Appendix E: Response to Public Submissions

Drawing Title
Illustrative Shadow Diagrams
Shadow Diagrams Equinox 21st March/September

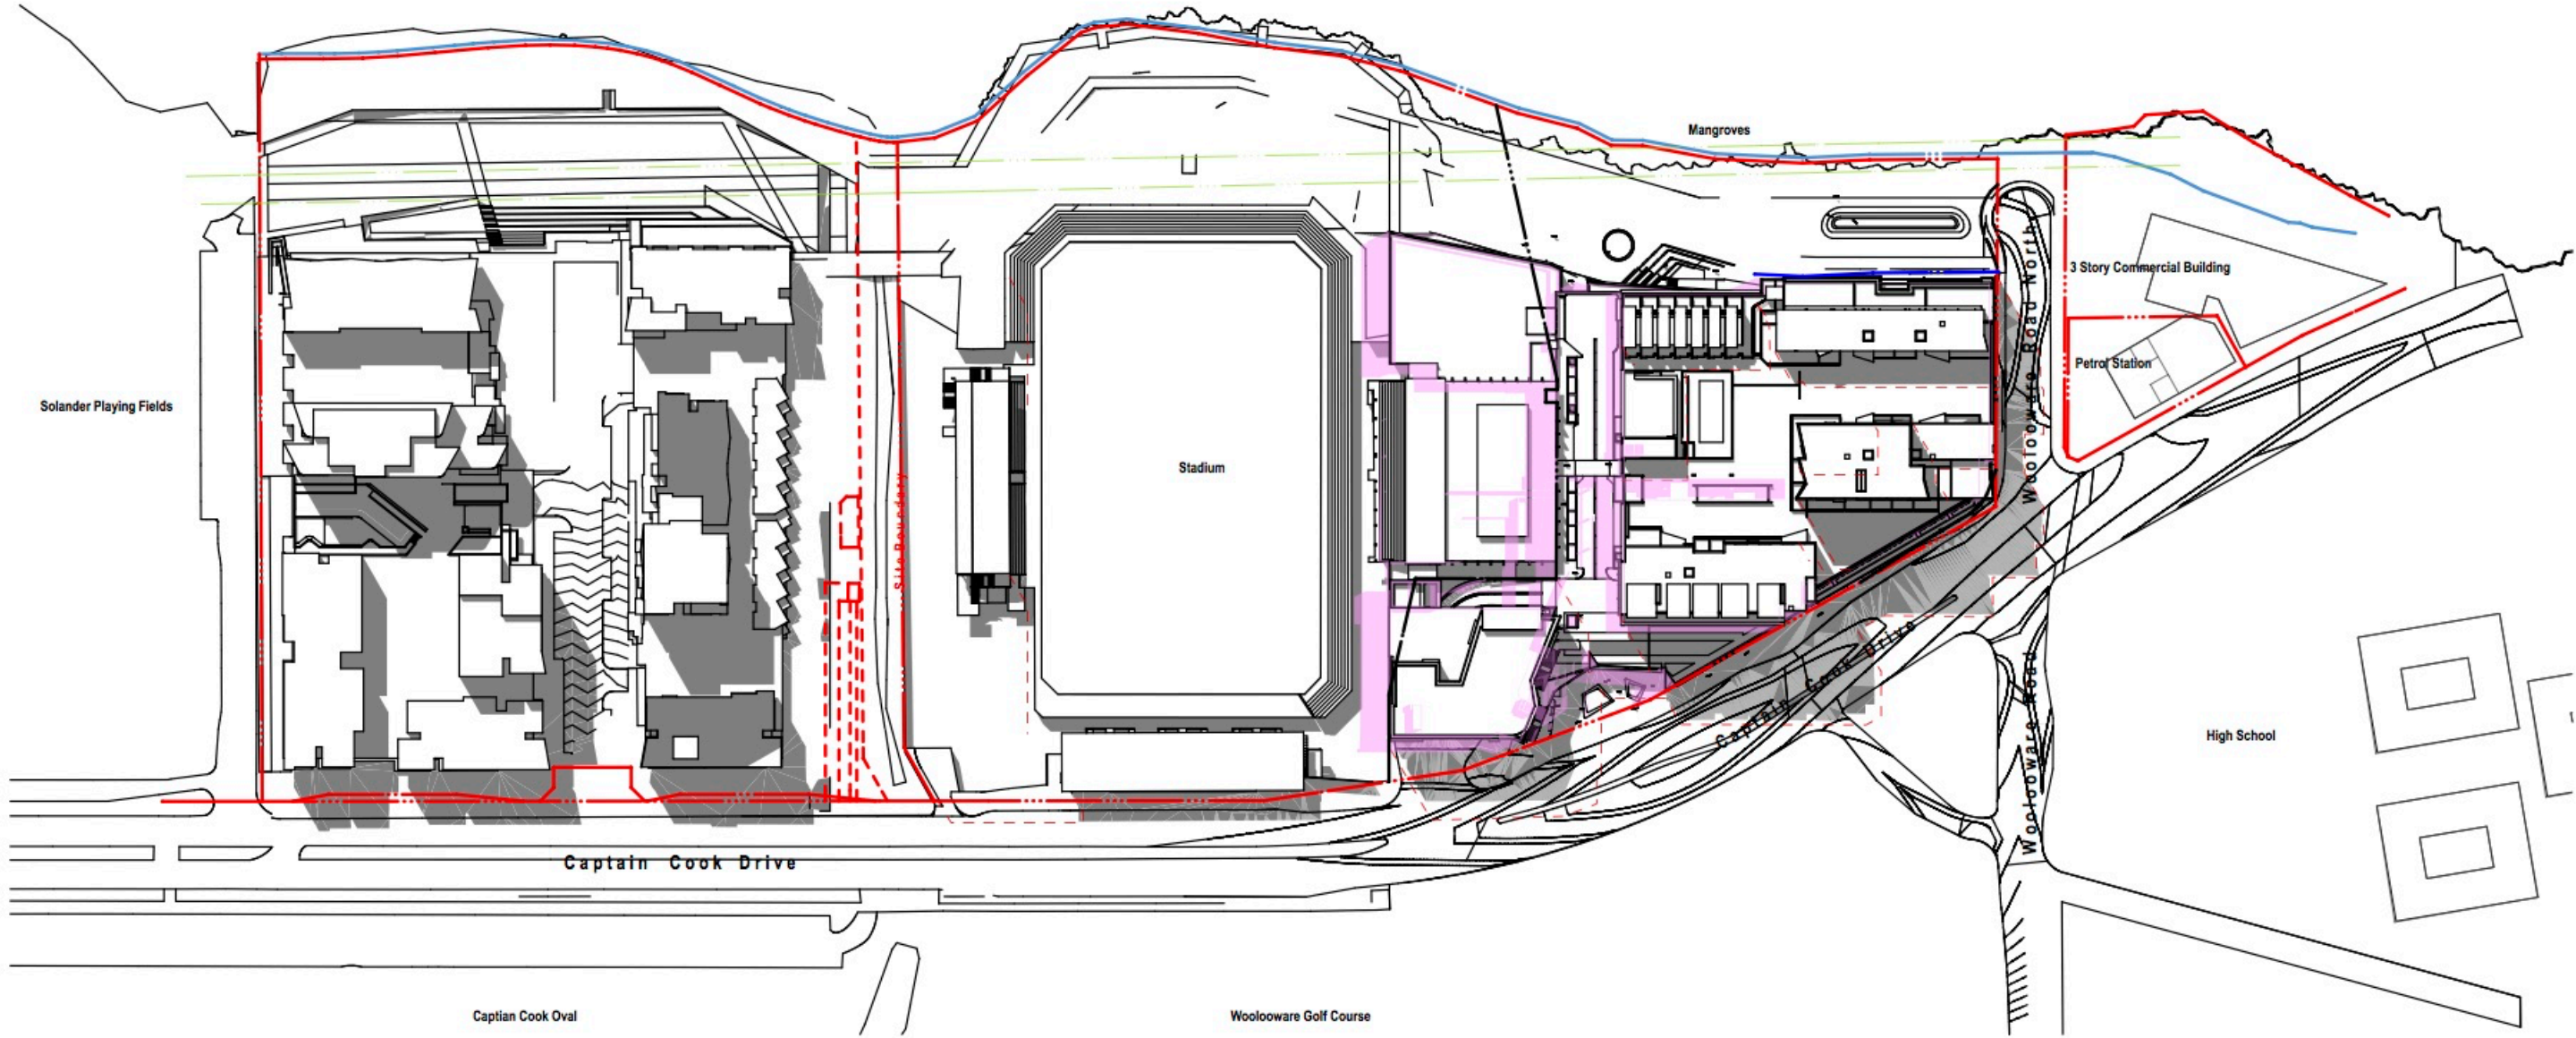
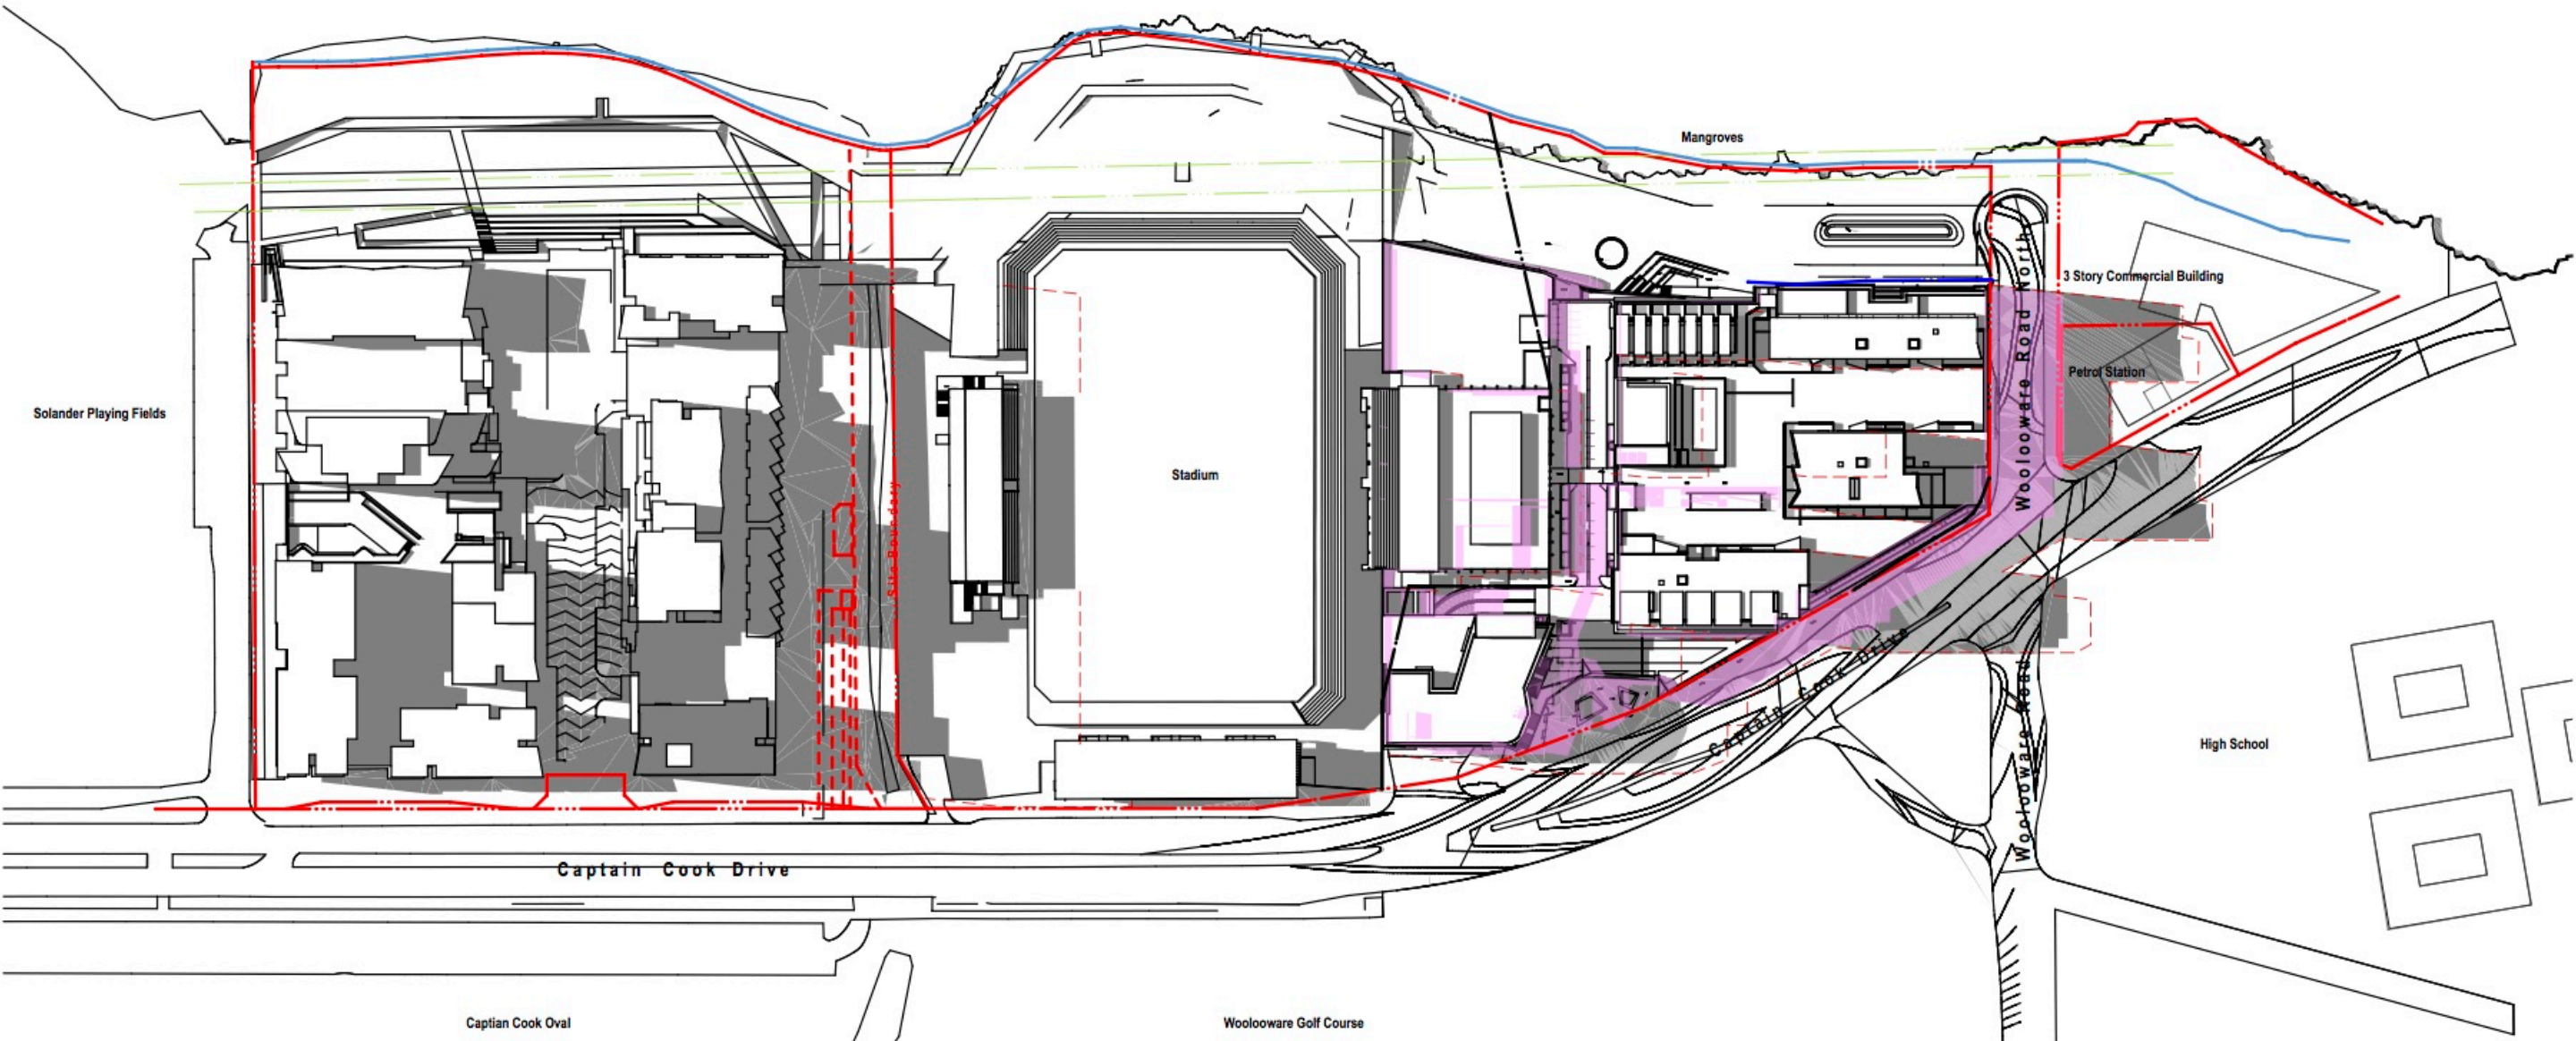
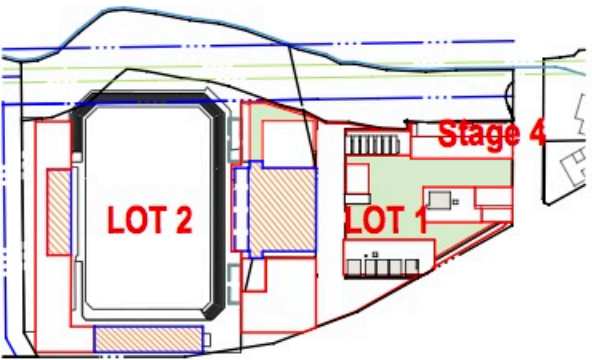
2	Overshadowing <ul style="list-style-type: none"> The proposed development will overshadow Woollooware High School. 	Shadow diagrams have been prepared, which demonstrate that shadow impacts to Woollooware High School impact on a small area of the school, with the greatest impact occurring at 3pm in the afternoon.
1	Electromagnetic Radiation <ul style="list-style-type: none"> Public health risk due to proximity to high voltage electrical wires. 	Multiple assessments have been undertaken throughout the course of the development in relation to electromagnetic radiation, which have established that any risk is low.
3	Active Transport <ul style="list-style-type: none"> Bike share will bring locals and tourists together Bike sharing will reduce traffic congestion Active transport will encourage health and wellbeing benefits 	These active transport measures are part of Capital Bluestone's commitment to reducing private car usage and providing benefit to the wider community, and it is appreciated that these measures have been received positively.
